Ref: APPROVAL. 2008/0551 : 47 DARTON ROAD, CANTWORTH

Our clients wished to carry out revisions to the approved elevation details as you considered at the time these could be treated as amendments to the original approval.

PROPOSED FIRST FLOOR LAYOUT

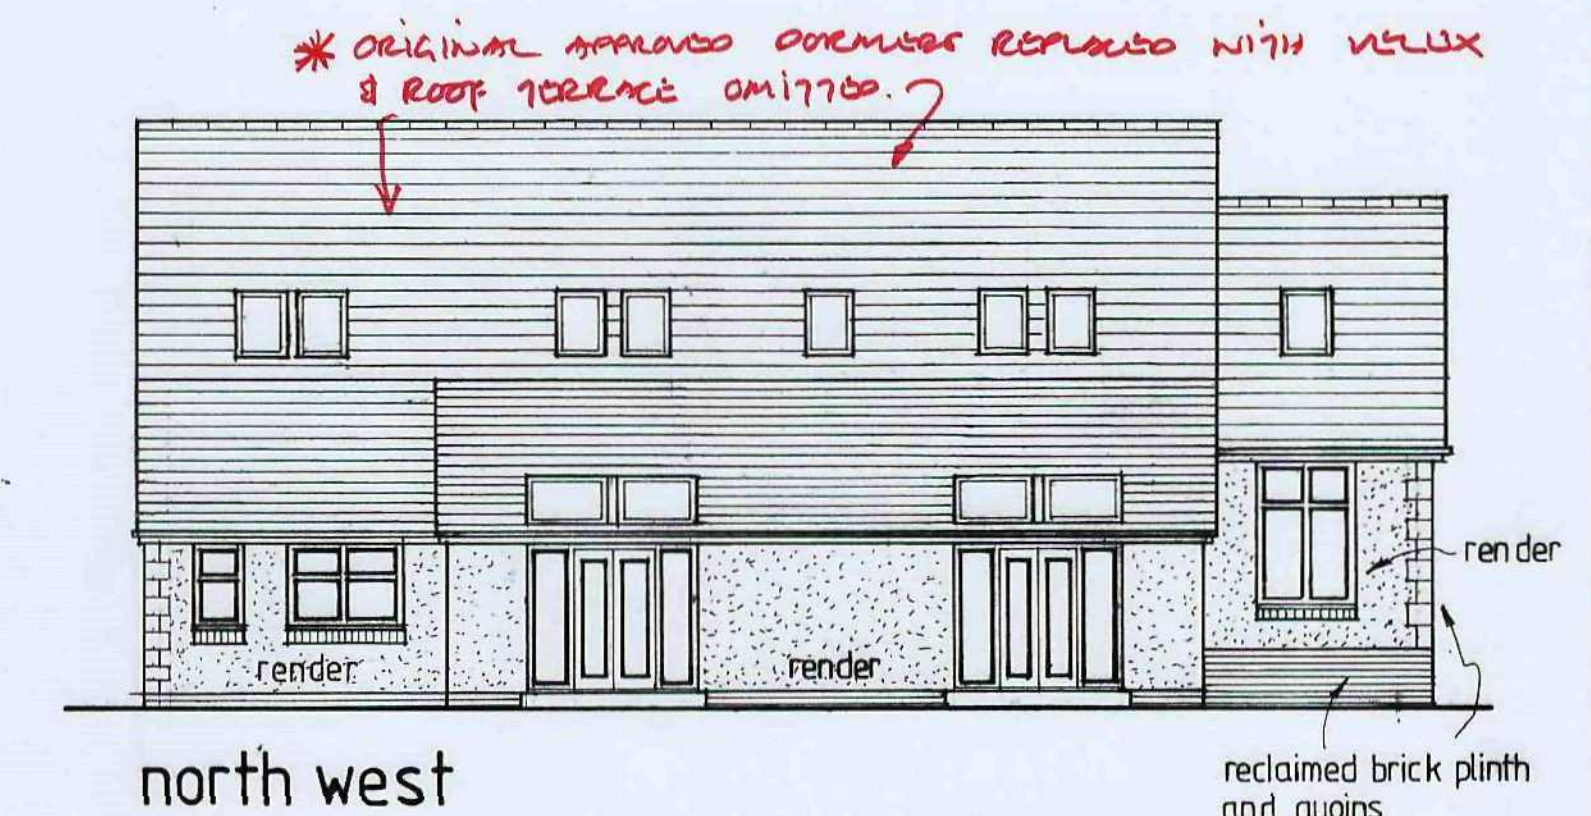
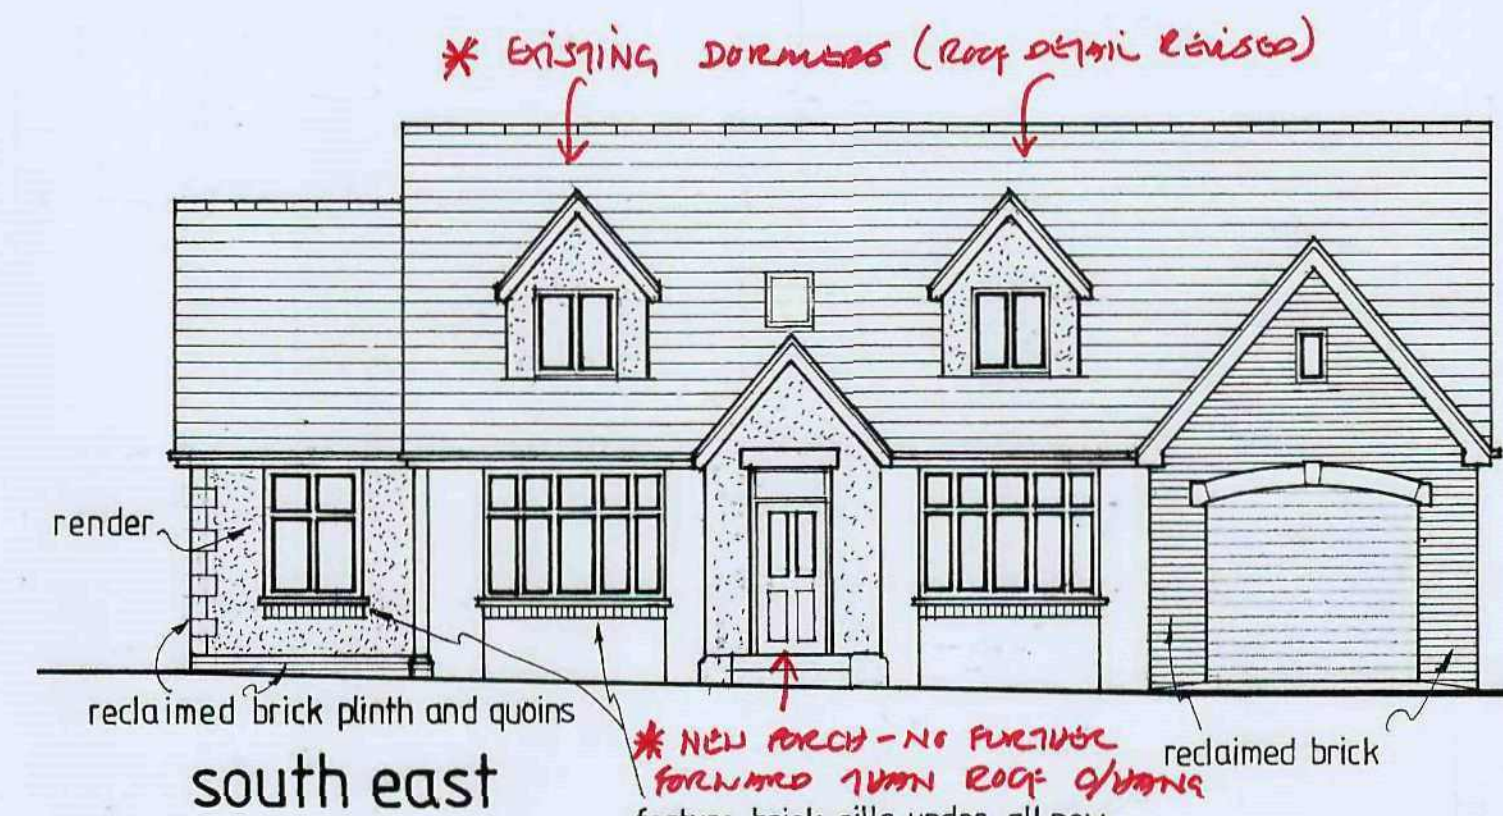
We enclose 2 copies of drawings with the revisions highlighted for clarity & we look forward to your confirmation that these are acceptable at your earliest conv.
Kind regards. Peter
